Written summary of oral submissions made at Compulsory Acquisition Hearing 1 on behalf of Marathon Asset Management MCAP Global Finance (UK) LLP (“Marathon”)

- 1.1 This document summarises the submissions advanced by Marathon Asset Management MCAP Global Finance (UK) (“Marathon”) at Compulsory Acquisition Hearing 1 on 2 May 2024.
- 1.2 The main items for discussion were the Applicant’s case for Compulsory Acquisition and temporary possession, site-specific issues for the Applicant and site specific representations by Affected Persons. Other topics also included statutory undertakers, Crown land and funding.
- 1.3 The hearing opened at 10am at the Sandman Signature London Gatwick Hotel, and closed at 1pm.

Title: **Surface Access Highways Plans General Arrangements APFP Regulations 5(2)(o) Sheet 1**

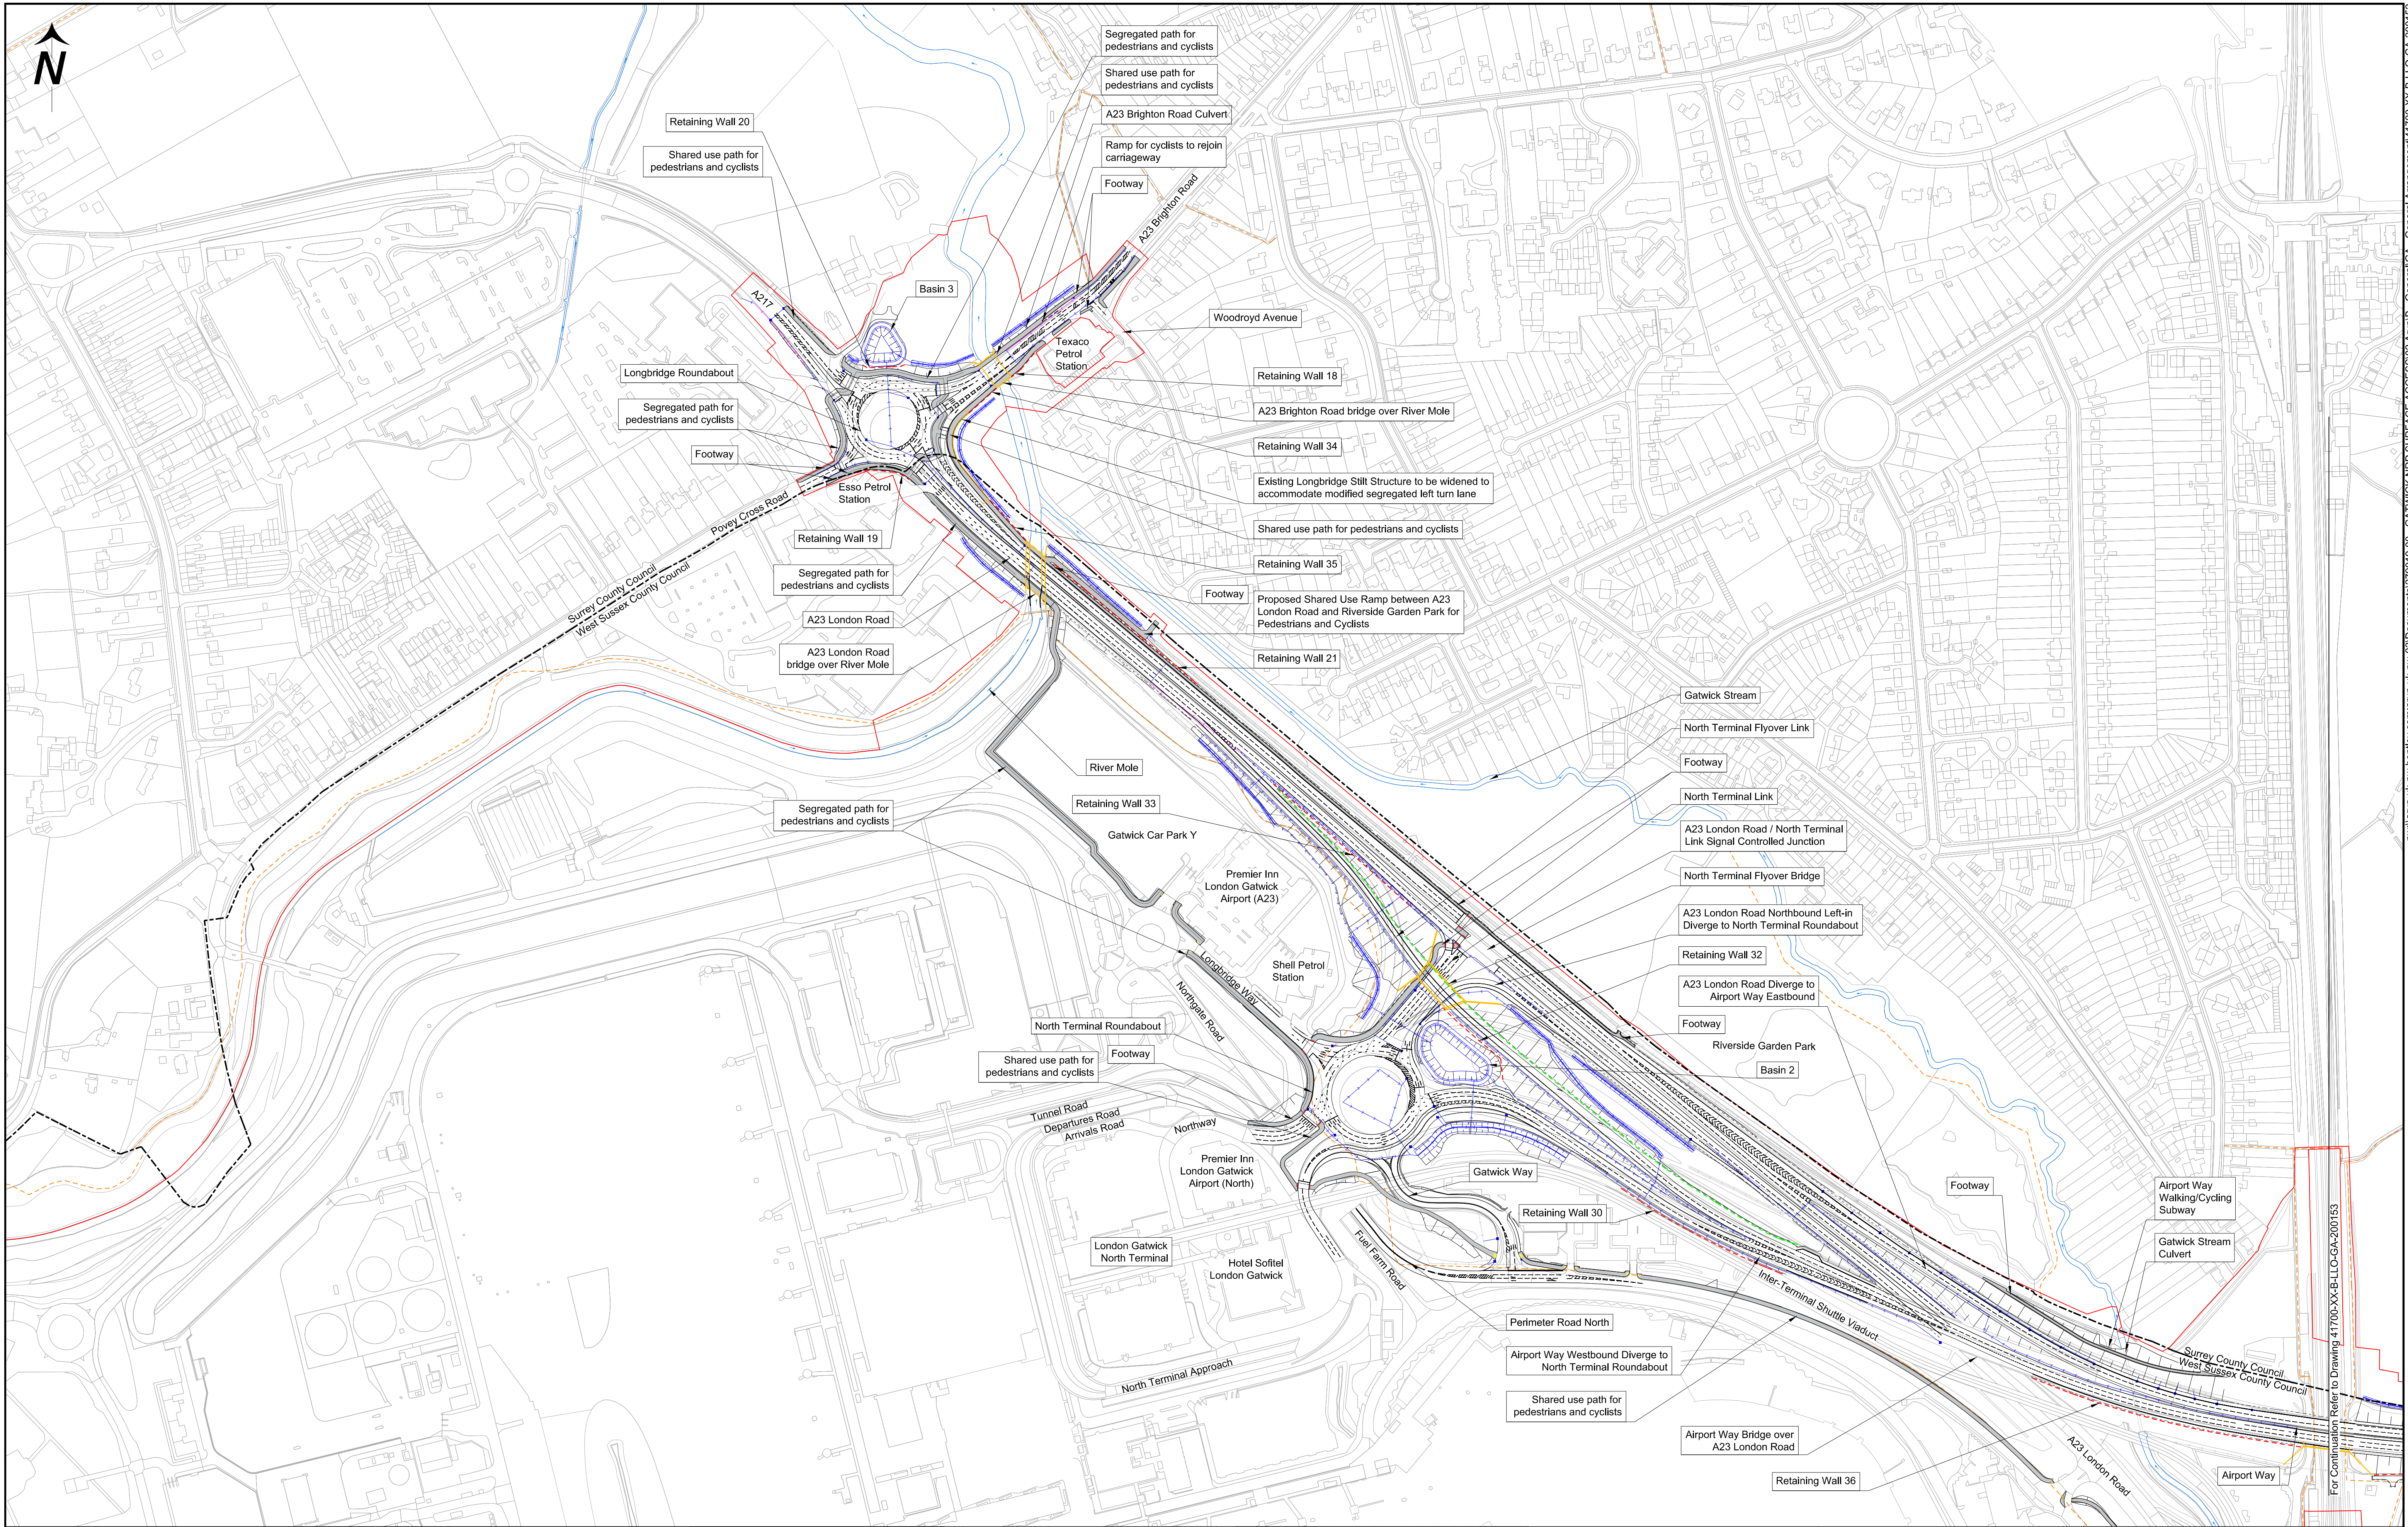
<p>c. As matters stand, the DCO (a) would allow permanent acquisition of ALL the ‘pink’ land and there is no enforceable mechanism to require GAL to take less; and (b) permits the acquisition of the only access into the hotel and makes no provision for a new temporary or permanent access.</p> <p>d. In the absence of concrete, deliverable and legally secured provision for an alternative access, the DCO therefore leaves the entire viability of the Hotel at risk, and by permitting wide ranging permanent acquisition, risks compromising the future development of southern parcel.</p> <p>4. If agreement cannot be reached with GAL, Marathon will have to look to the ExA to take action to avoid this situation. It is therefore important that the ExA is properly appraised of the issues now.</p> <p>5. The key issues are:</p> <ul style="list-style-type: none">a. Scale of land take;b. Clarity regarding the Northern Access proposal;c. Protection for services; andd. The need to mitigate noise effects and effects on the Hoppa Bus service. <p><u>Scale of land take:</u></p> <p>6. Marathon acquired a portfolio of hotels in 2021, which included the Holiday Inn Gatwick. As a prudent owner, Marathon has considered how to enhance this property. The existing hotel has 216 bedrooms, but past planning permission has allowed for up to 300 bedrooms, indicating the site could be utilised more intensively.</p> <p>7. Marathon is concerned that Gatwick Airport Limited's (GAL) proposals could impact the hotel's development potential. In Marathon’s view, reducing the permanent land take would mitigate against the risk of GAL’s land requirements and Marathon’s ambition to maximise its site competing. It is not clear why all the land is included for permanent acquisition (particularly parts of plots 1/057 and 1/026). Indicative permanent road layouts for the Longbridge Roundabout do not indicate the need to permanently acquire all of the land.</p> <p>Information Request 1: Please can GAL provide plot specific justification for the extent of proposed permanent acquisition of land and rights at Marathon’s Property including details of the underlying technical design of the highway works relating to the Longbridge Roundabout.</p>

<p>Longbridge Roundabout. It is also the option GAL has confirmed it is working up. However, Marathon still had questions regarding feasibility, in particular:</p> <ol style="list-style-type: none">a. how the right turn into the hotel from the A217 would be prevented as per the current access arrangement,b. providing a layby for the parking of the Hoppa Bus. <p>17. At the meeting on 27th March where the design options were discussed GAL agreed to provide further detail regarding the design standards and concepts, to enable agreement that the design of the temporary access would be suitable in advance of the detailed design stage. Further design work needs to be undertaken to be certain that the proposed northern road is to an appropriate standard and in a format that integrates with hotel's internal road layouts.</p> <p>18. GAL also confirmed that layby parking and right turn prevention would be looked at in detail and form part of the updated information pack provided to our client. We have yet to receive this information but understand this is still being worked on.</p> <p>19. This information is critical so Marathon and the ExA can be assured that a safe and suitable temporary access can and will be provided to their hotel. Any other outcome risks the closure of the hotel.</p> <p>20. Critically, the provision of the temporary access requires the use of land that is outside of GAL's proposed compulsory acquisition powers (cf. GAL response to ExAQ1 CA 1.7 [REP3-072]). It is therefore imperative that an agreement is achieved in a timely manner.</p> <p>21. Information Request 2: Please can GAL provide the details and drawings relating to the concept design for the proposed temporary access to the north of the Property to demonstrate to Marathon and he Ex A that it is a satisfactory solution. This should include details of layby parking and right turn prevention and also identify any land outside of the Order Limits required for the proposed access.</p> <p>Proportionality of interference with rights/injurious affection:</p> <ol style="list-style-type: none">22. Para 8 of PINS' Guidance on Compulsory Acquisition notes that interference with the private interests of Affected Persons must be shown to be necessary/proportionate23. Impacts will not be necessary/proportionate if they can reasonably be avoided through mitigation.24. There are two aspects of particular concern outstanding:
